**A122 LOWER THAMES CROSSING (REF: TR010032)  
DEADLINE 6 SUBMISSION**

**LINFORD LAND GROUP - AFFECTED PARTY REFERENCE: AP1631**

**MULBERRY STRATEGIC LAND LIMITED – AFFECTED PARTY REFERENCE: AP1581**

Plate 72

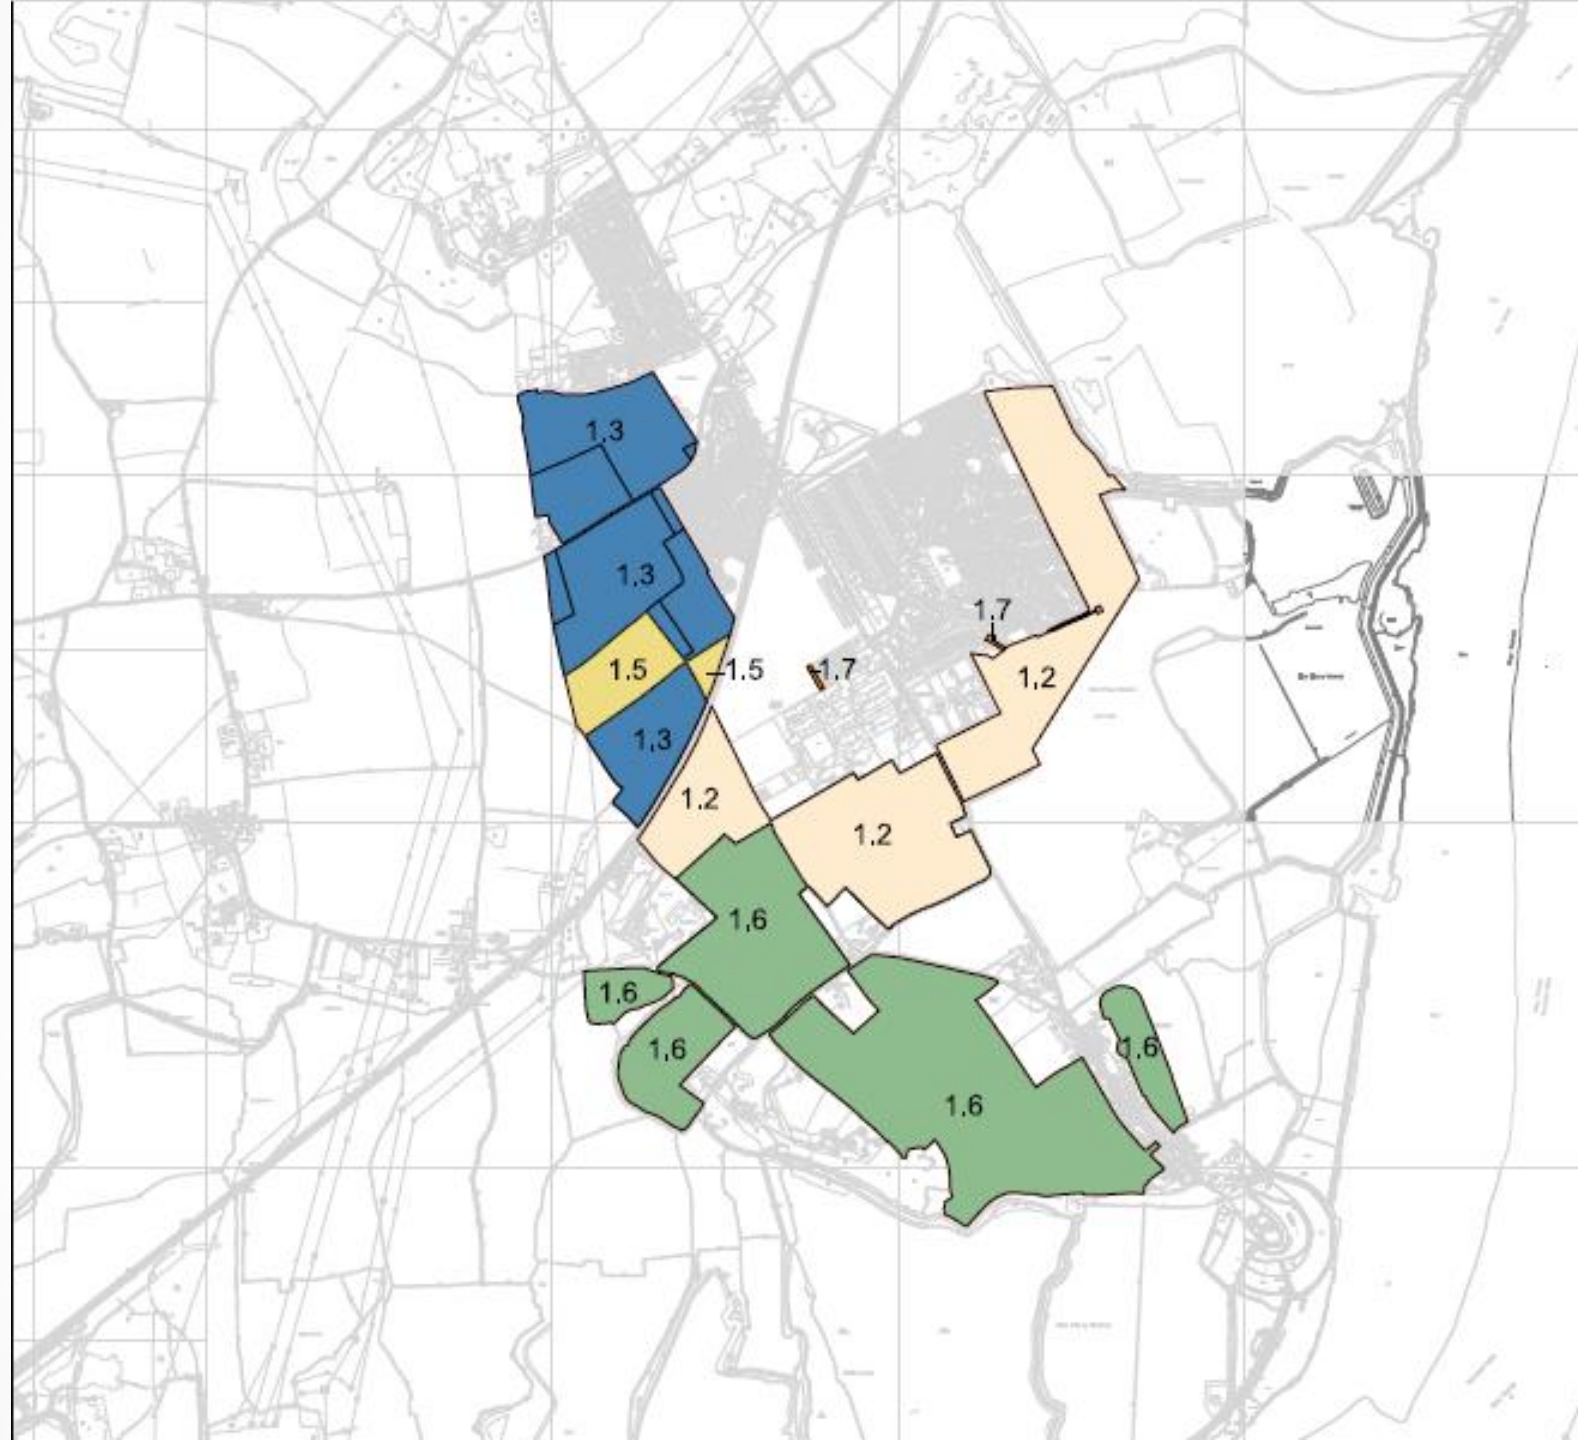
<p>The land south of the Muckingford Road has recently been subject to the Applicant's Change Request MRC03 whereby the order limits have been amended and there has been a subsequent removal of 42 acres of our client's land from the order limits.</p> <p>However, some land south of the Muckingford Road is still required for temporary possession and temporary possession with permanent rights (<i>see plot numbers referenced under Linford Borehole and Temporary Water Pipeline below</i>)</p>
<b>Plates 70 &amp; 71</b>	Plates 70 and 71 show extracts from the LTC Land Plans REP5-008 (Sheets 23 and 24) with the Linford Land Group ownership comprised within the areas in the blue boxes.
<b>Plate 72</b>	Plate 72 shows the extent of land over which Mulberry Strategic Land (AP1581) hold option agreements as coloured on Plate 72 – with land within the Linford Land Group ownership numbered 1.3 (shaded blue)

- ▶ Ecological Mitigation Land

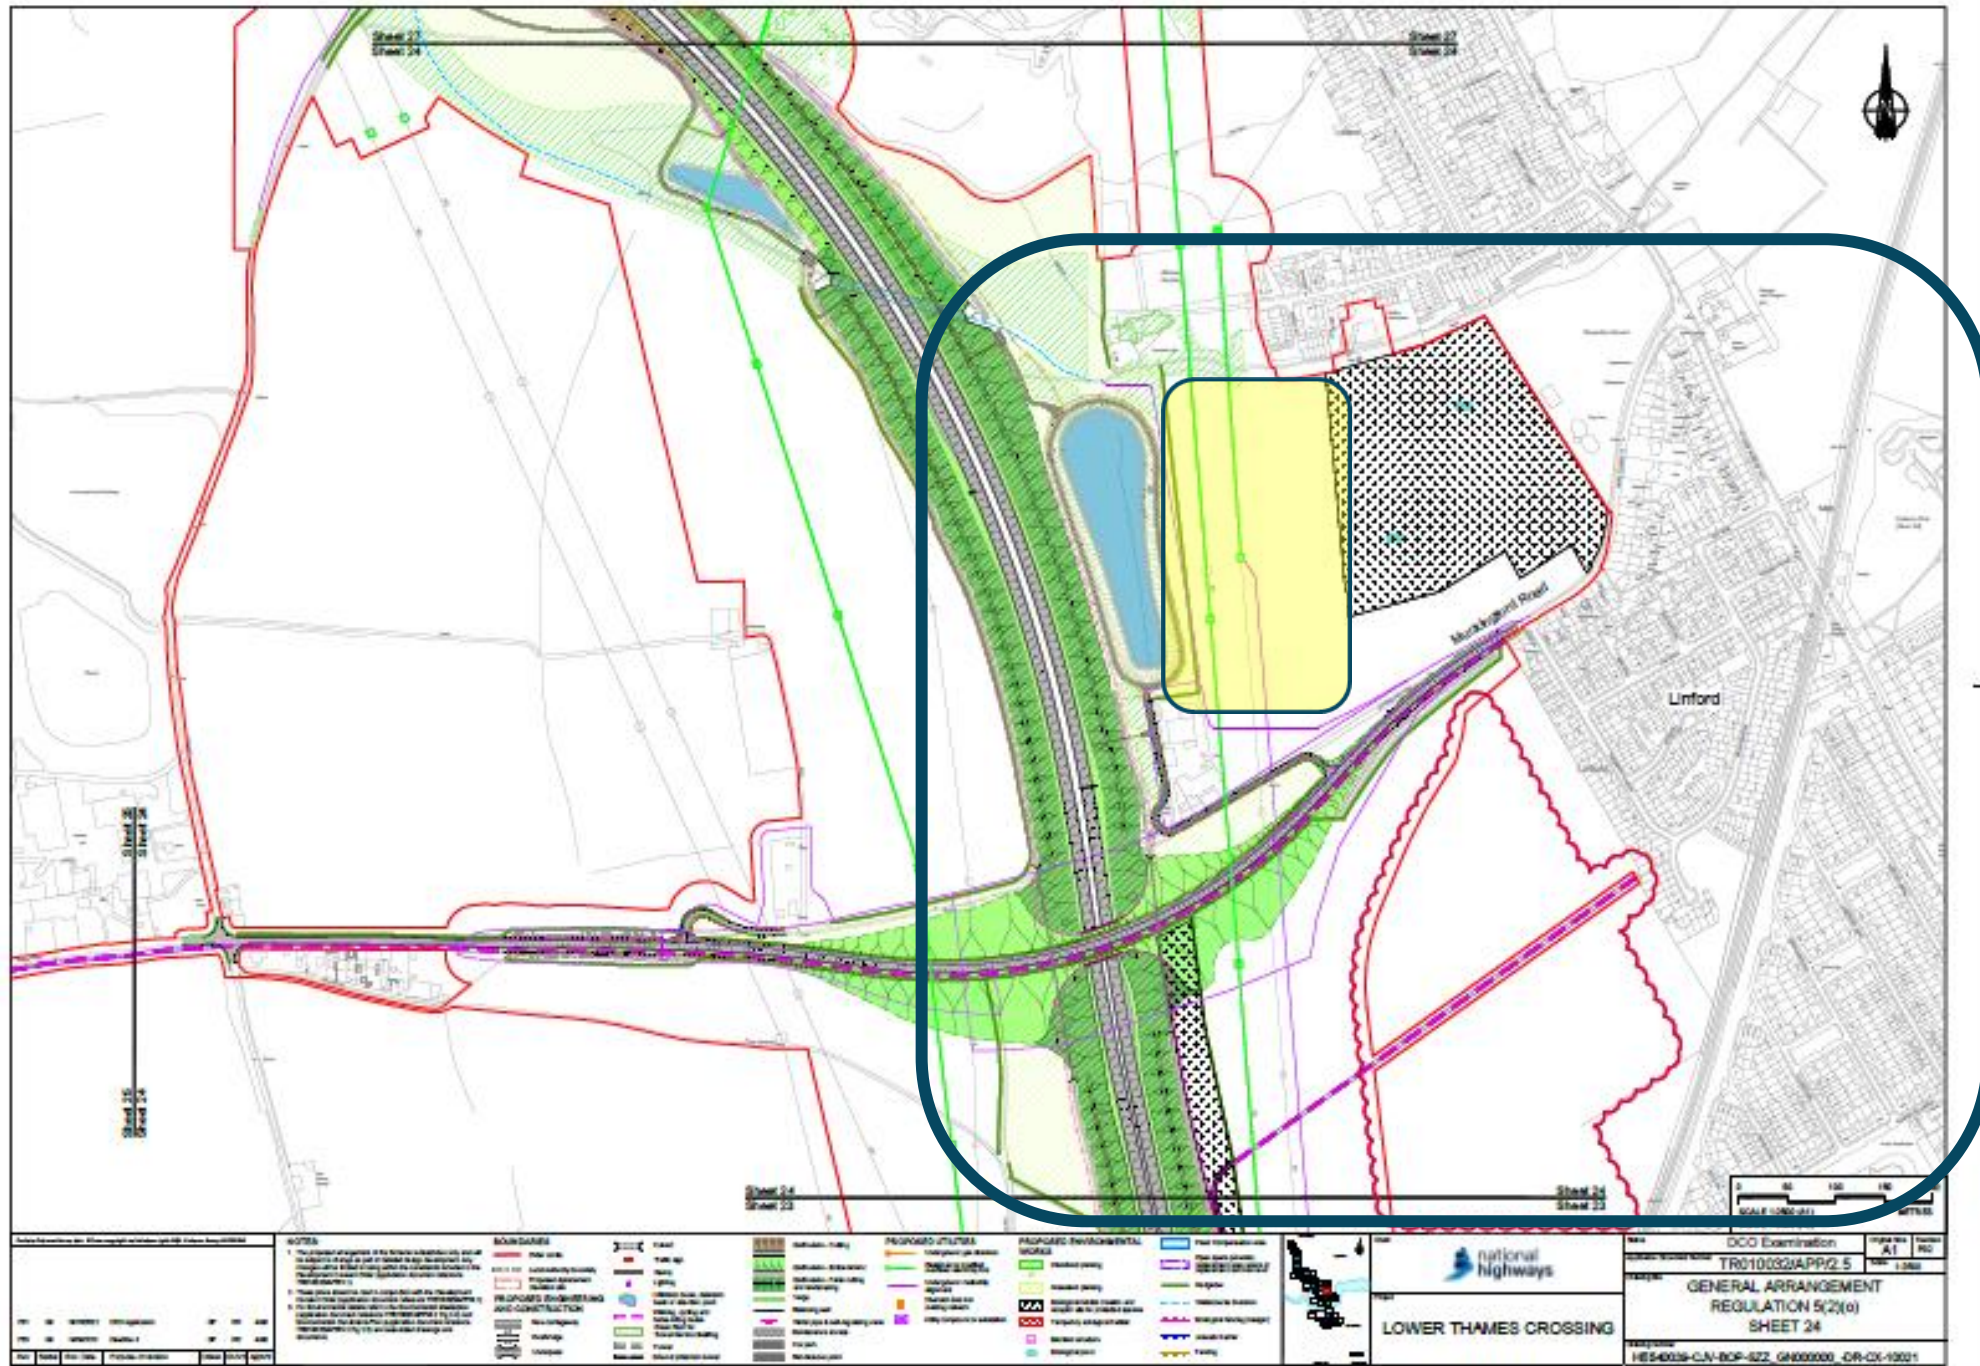
<p><b>Ecological Mitigation Land</b></p>	<p><b>Plate 77</b> – shows the Applicant’s proposed Open Mosaic Habitat (black hatched area) with unused zone shaded yellow within utilities corridor, together with the Applicant’s proposed drainage retention pond to west of land parcel - all within our client’s planning application red line boundary.</p> <p><b>Plate 78</b> - shows the zone shaded yellow within the utilities corridor and the drainage retention pond to west of land parcel overlaid onto the Land Use and Amount Option 1 (with LTC) plan.</p> <p>The area of the Applicant’s mitigation land in its proposed location is 13.69 acres - equivalent to approx. 170-200 units.</p> <p>The area of land under temporary possession within the utilities corridor and part of the road frontage in the yellow shaded area is approximately 13/14 acres.</p> <p>As submitted orally at CAH3, we consider that the mitigation land proposals for this area north of the Muckingford Road should be reconsidered to fully explore the use of land within the utilities corridor shaded yellow to mitigate the impact on our client’s proposed development.</p> <p>The current design would render any land north of Muckingford road in capable of sustainable/viable development boundaries of the land parcels left post acquisition of the mitigation land and drainage retention pond areas by the Applicant.</p> <p>With reference to <a href="#">APP-511</a> – Project Design Report Part D: North to A13 Junction, the document refers to connectivity in the context of mitigation and habitats, particularly in the case of the Chadwell Link (e.g. para 5.5.6).</p> <p>The utility gap between the main alignment and the location of the open mosaic habitat as proposed north of Muckingford Road, does not seem to reflect that and is disconnected. If such a habitat is required, connectivity would suggest a mitigation area within the utility corridor immediately adjacent to the drainage retention pond is the better place for it.</p> <p><b>Our submissions are as follows:</b></p> <p><b>We would request a commitment from the Applicant to:</b></p> <ol style="list-style-type: none"><li>1) relocate the mitigation land into the existing utilities corridor and</li><li>2) to form a technical working group with Mulberry Strategic Land to agree the methodology and works timetable that would enable use of the land within the utility works corridor for mitigation.</li></ol>
